CM/32/20/PL

Land adjacent to Church Farm Barn, Horsemere Green Lane, BN17 5QZ

Change of use of land (B Storage) & erection of 1 No. detached single storey, two bedroom dwelling. This application affects the setting of a listed building & is a Departure from the Development Plan

PROPOSED BUNGALOW –
ELEVATIONS (1)

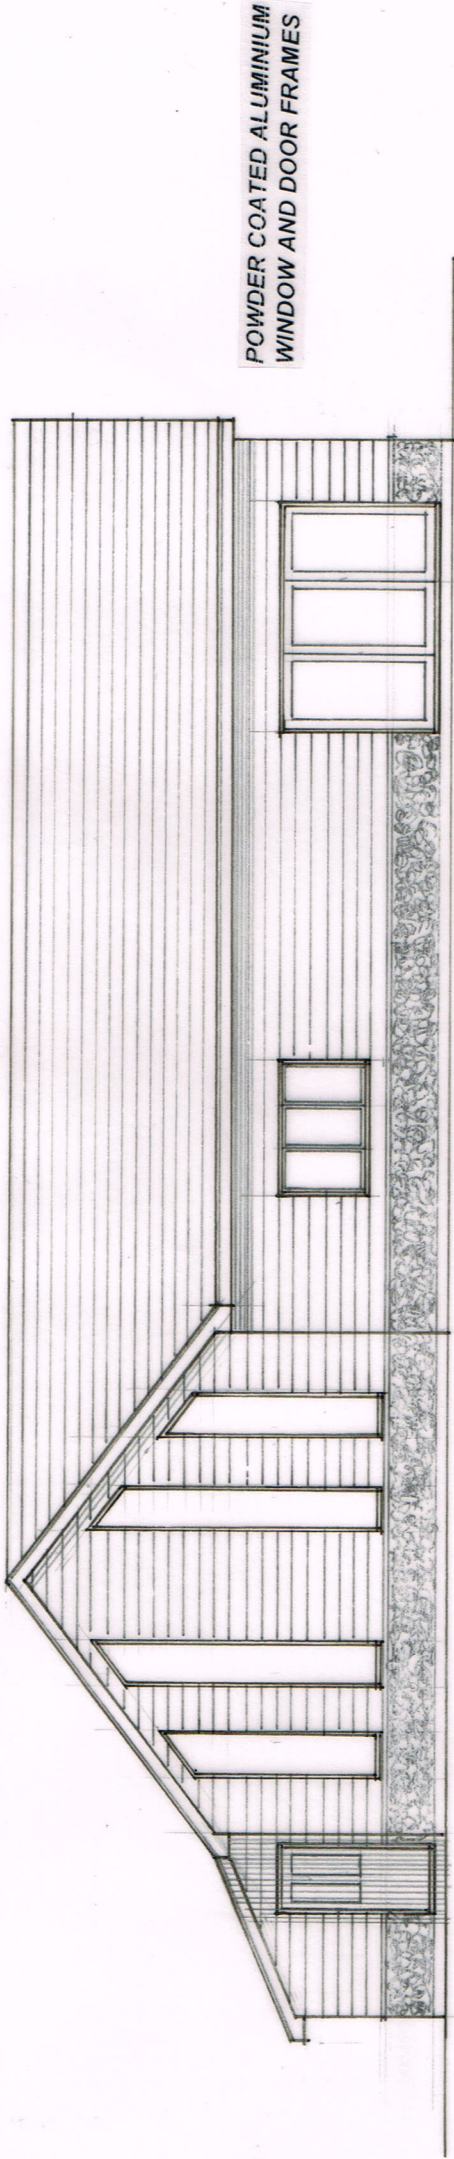
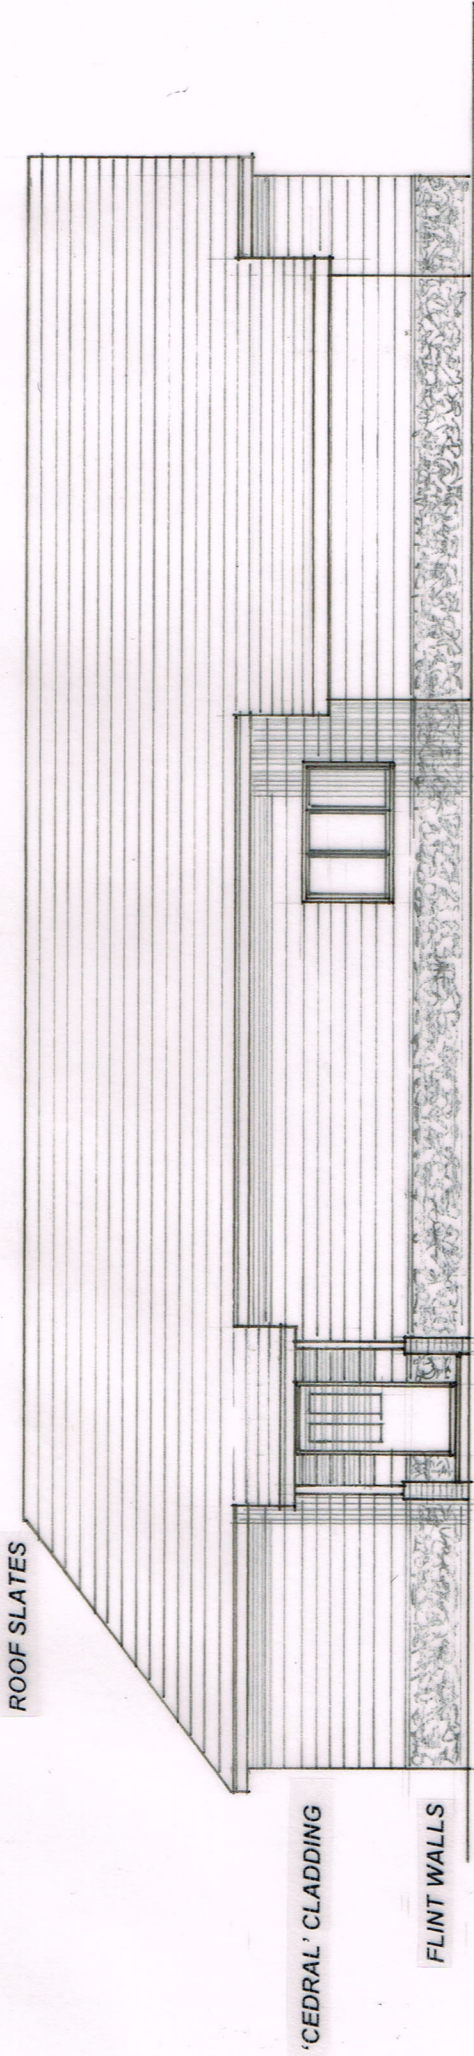
The application site is already used for storage of vehicles etc. but screened from the road by a mixture of vegetation and modern fencing. Whilst the change of use may be acceptable as it will introduce a more suitable use in the lane, I am concerned about the design of the proposed dwelling which, whilst attempting to be of agricultural character, is to be designed and clad in materials not traditionally associated with either the neighbouring listed barn or the more traditional buildings in the local area.

The neighbourhood plan character assessment (prepared as part of the Neighbourhood Plan) identifies that the lane is located within an area it refers to as 'traditional Climping'. Of note is the fact that the assessment for this character type states: "Much of the construction is traditional rural with pitched roofs of slate tiles or of thatch, some timber framing, and flint or rendered walls". There is no reference to cladding, and it does not appear to be identified on the main elevation of the listed barn. The use of the cladding on all of the elevations, especially one of modern construction is out of character with the buildings in the local area, as well as the listed building. Further, the fenestration on the South-West elevation is not reflective of the intended barn character and is therefore problematic. It is suggested that an alternative approach is considered which will better reflect the character of the area and complement the neighbouring listed barn.
